My Ref: AW/128/16/T- 8/12 Wychwood-1

6th May 2016

**OBJECTION & Tree Preservation Order Application, in THE CRAIGWEIL HOUSE
CONSERVATION AREA, in the grass verge outside a vacant plot between 8 & 12
Wychwood Close.—AW/128/16/T**

DRAWING TITLE
Site Plan, Block Plan and Location Plan

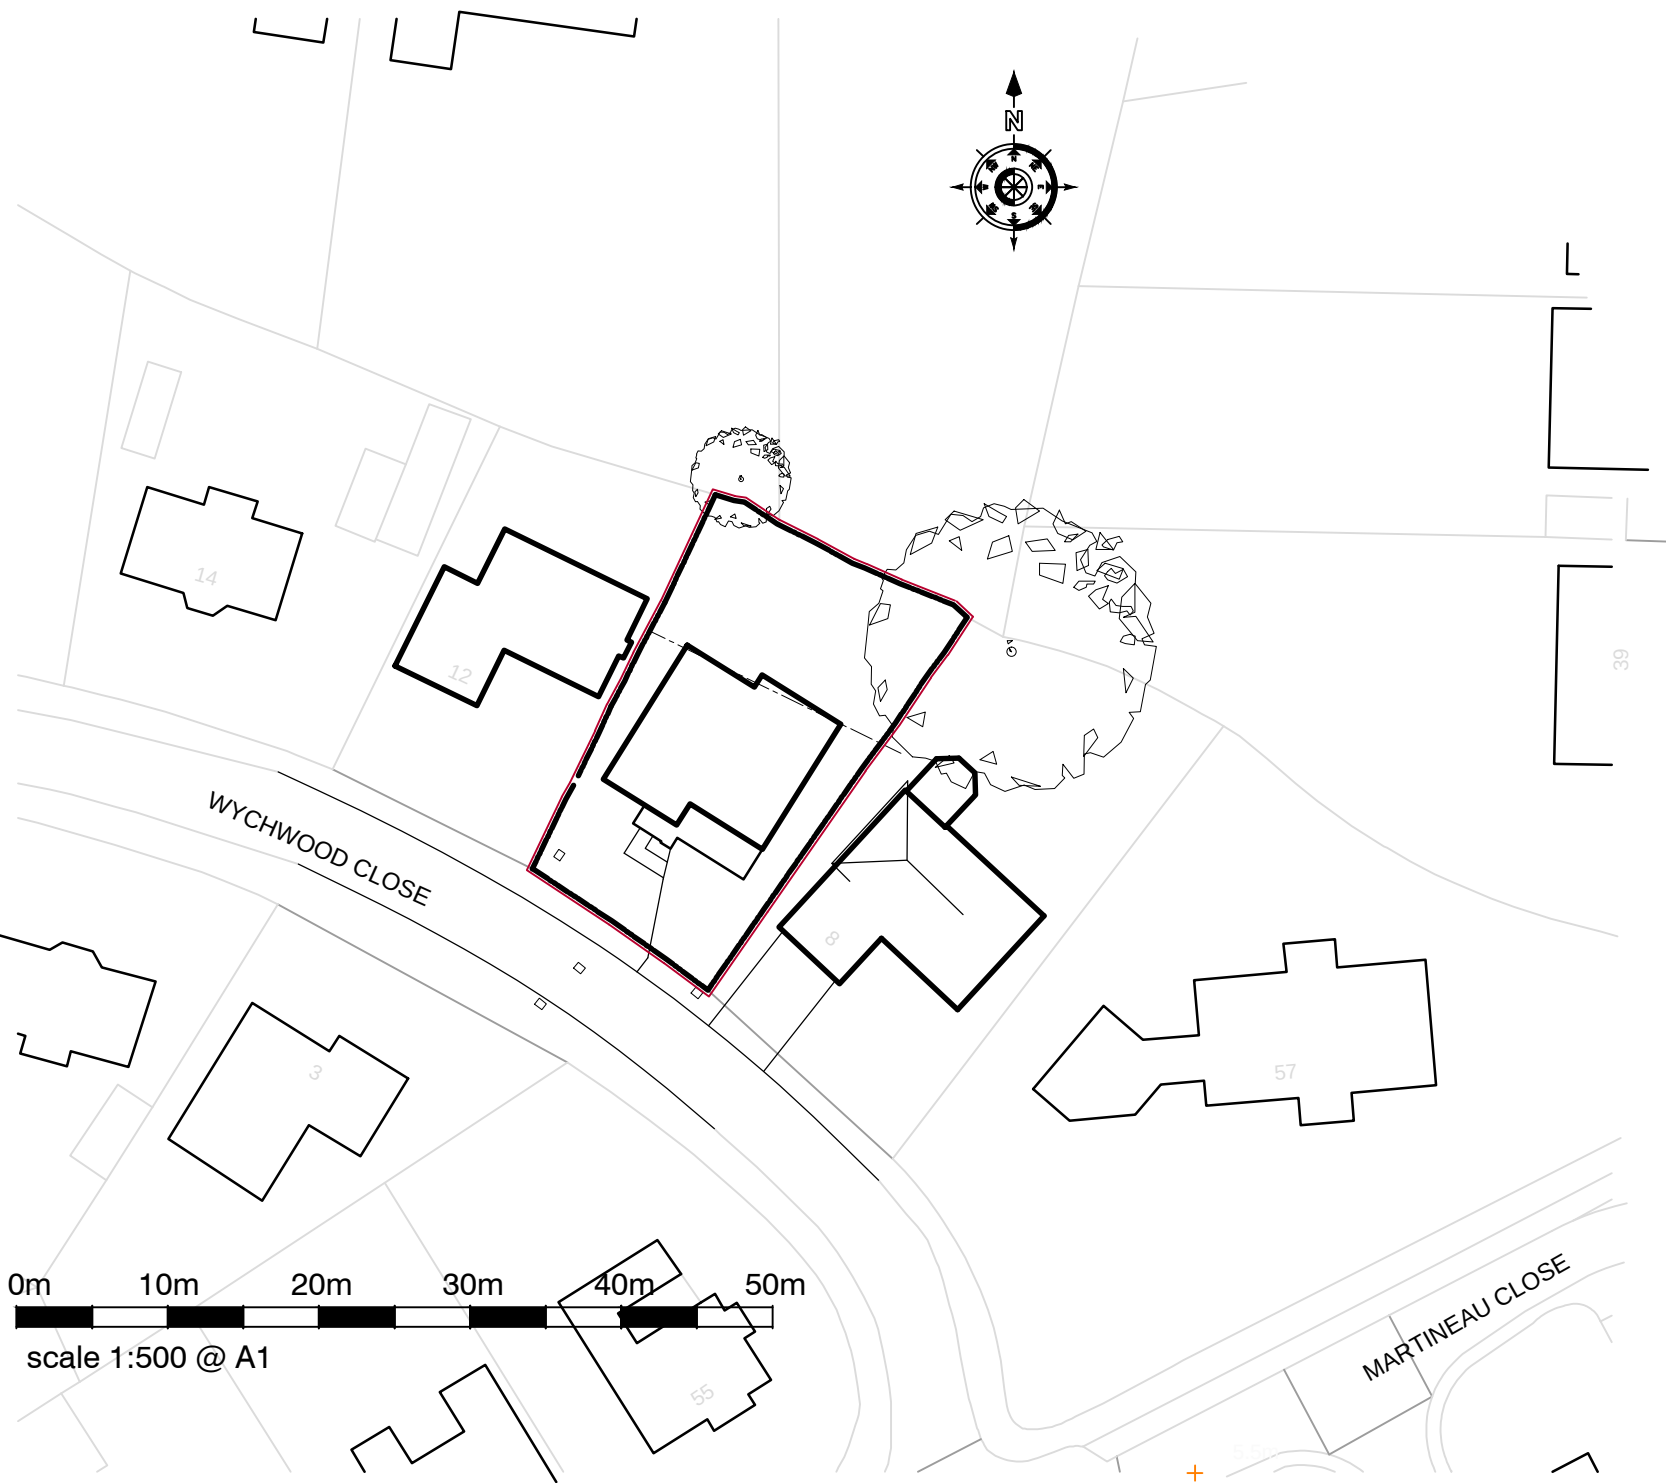
4. The proposed house is too close to the frontage of the plot to take account of the existence and maintenance of this valuable tree. In addition, the Applicant says his mechanical and other equipment on site will damage or destroy the tree. The **Root Protection Areas of this Red Oak will be seriously compromised by this development** and as a Town Planner himself, the Applicant knows that very well, stating so as he does in his application. It seems somewhat arrogant to put the building horse first, after the tree cart in this case! It is for an Applicant to work around existing tree-scape/specimen, rather than tell Planning Officers and in this case local residents, what they must do to comply with **HIS PLANS. The tree is not his to do with as he wishes** and Planning Law protects amenity trees as this delightful and stately Red Oak is.

TREE PROTECTION PLAN

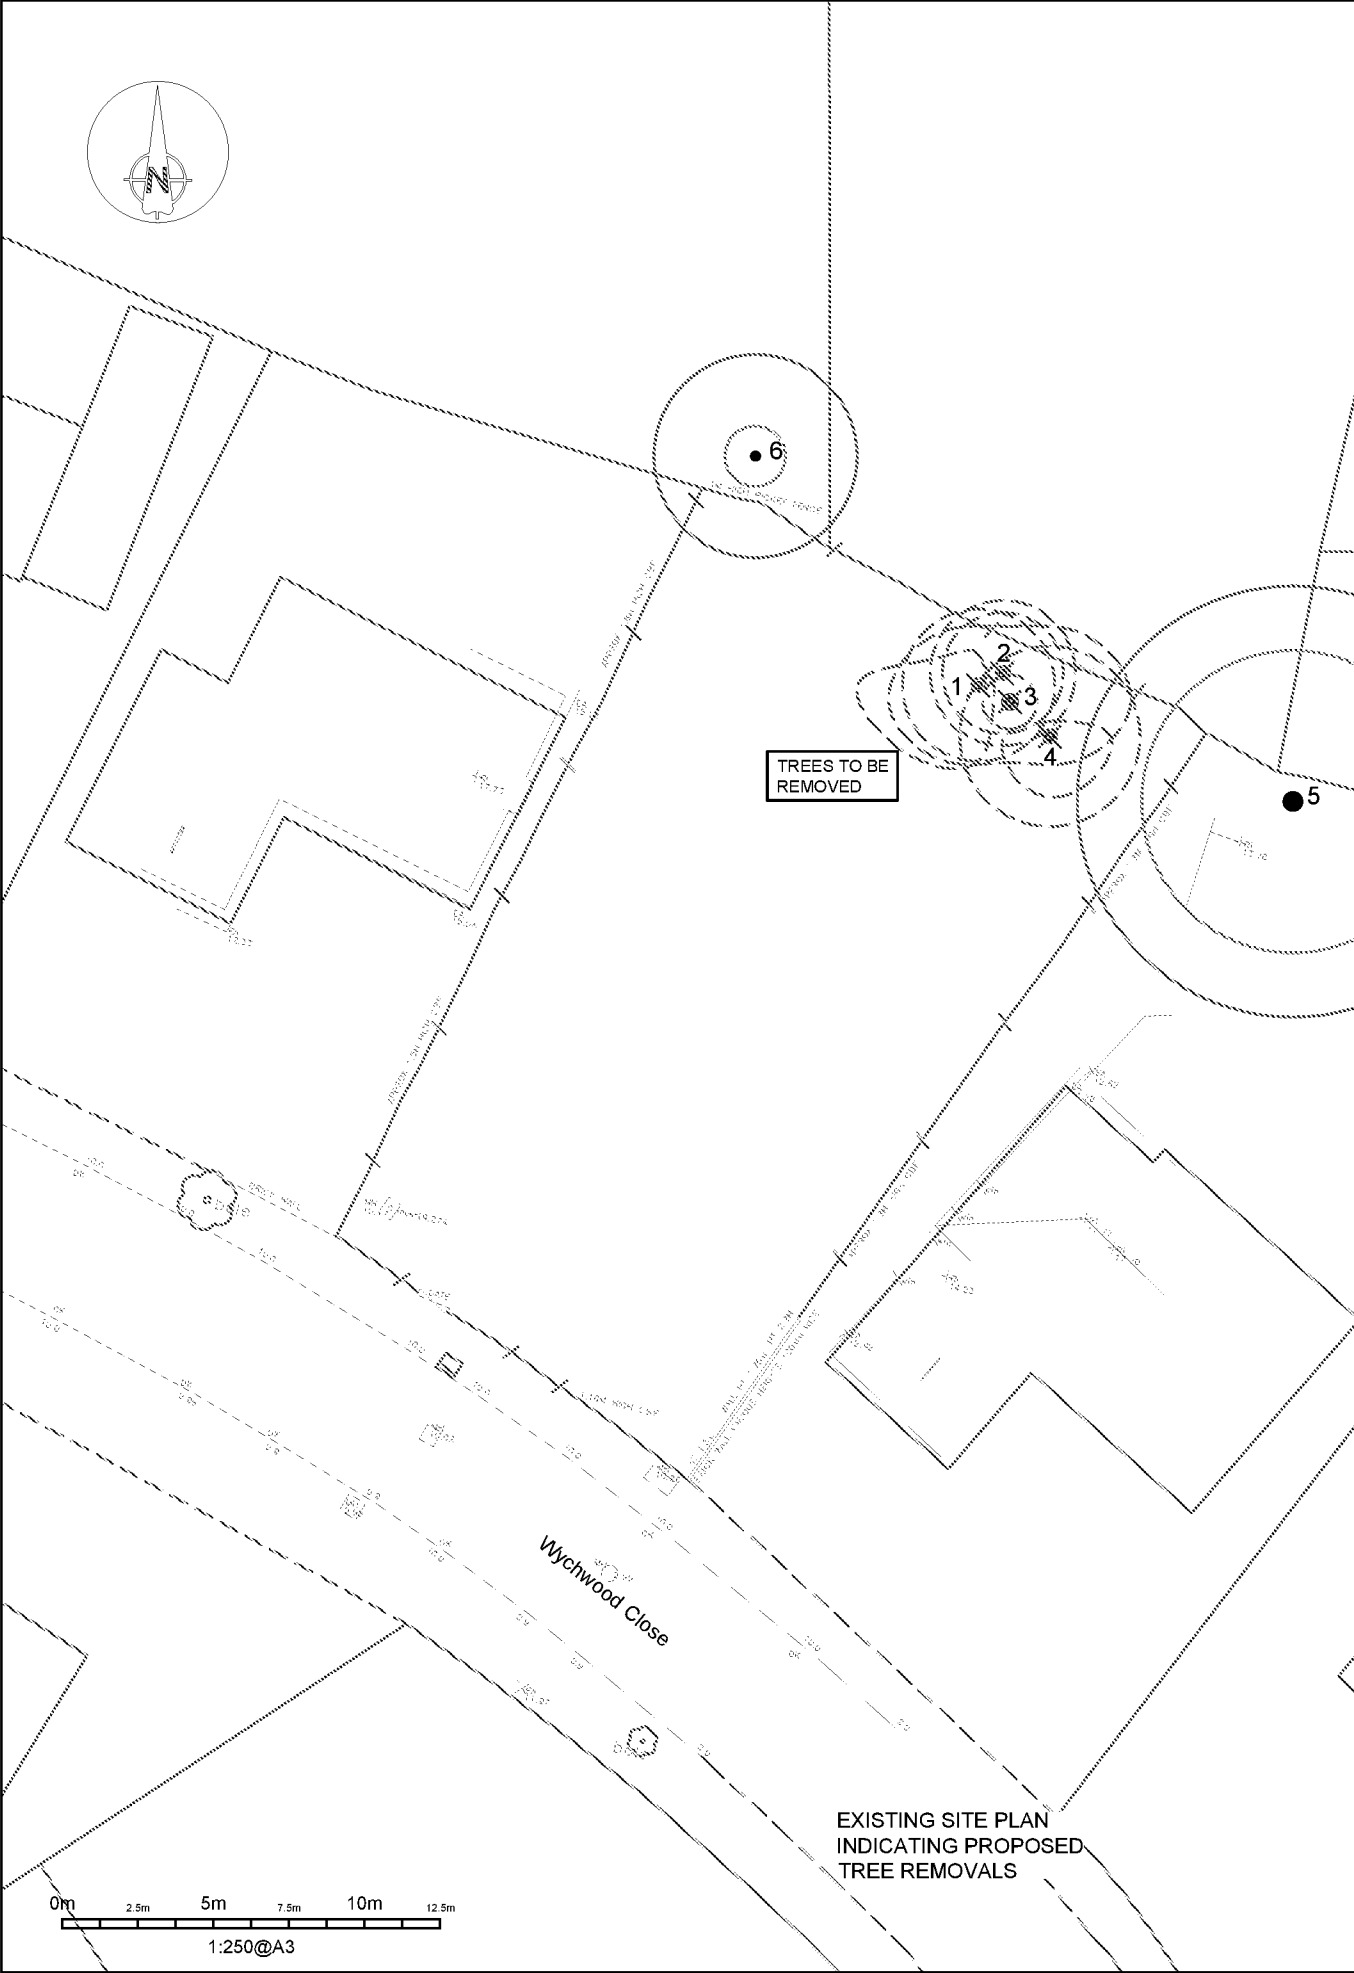
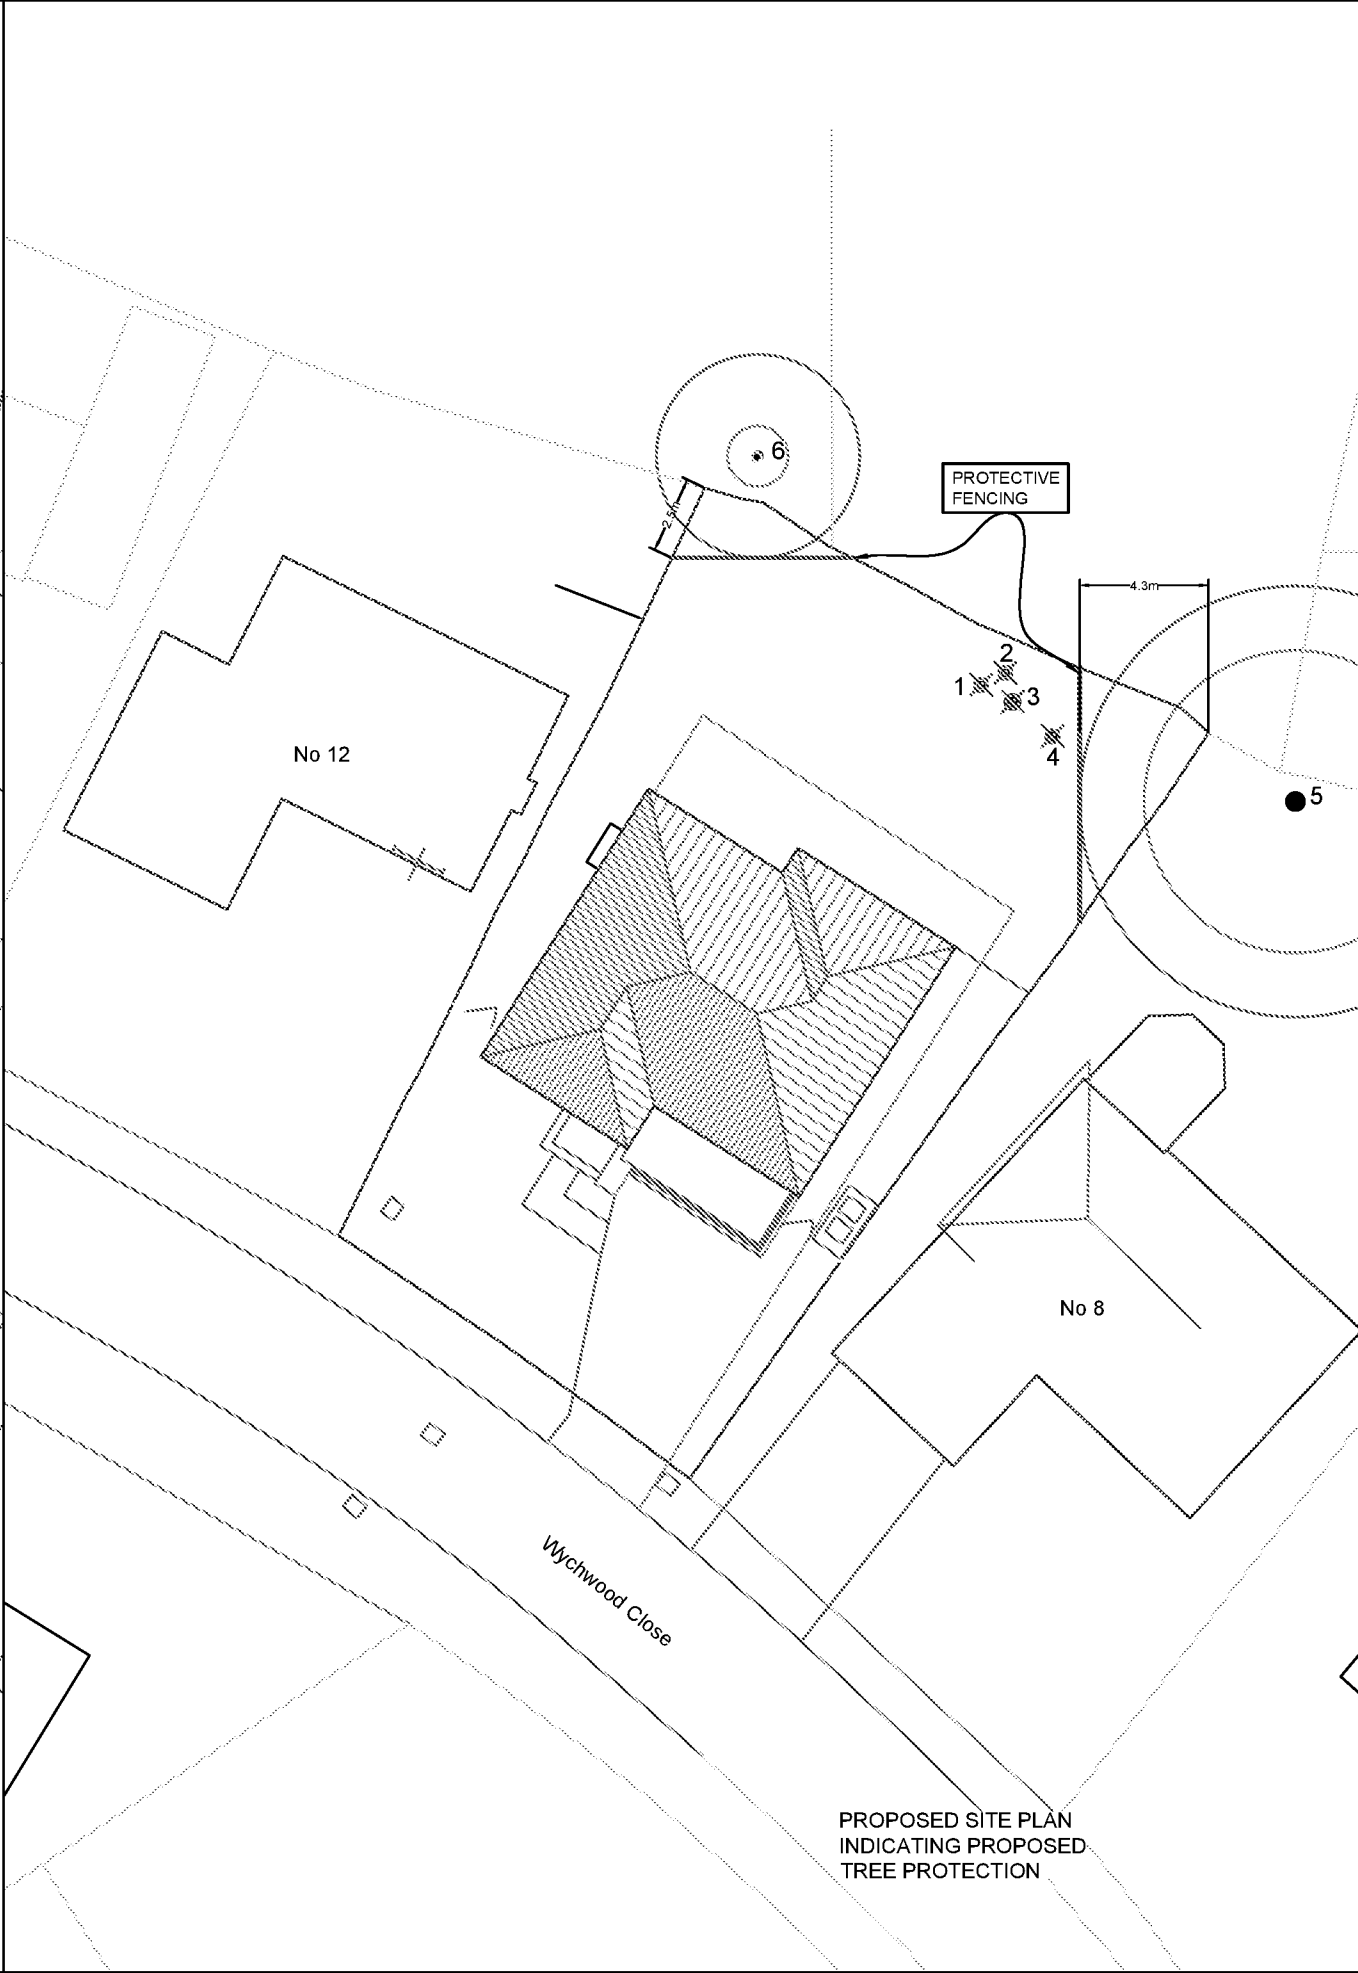
6. BS 5837:2012 clearly lays out the RPA requirements and whose responsibility planning for construction it is and Mr. Ellis as an expert knows that well too.
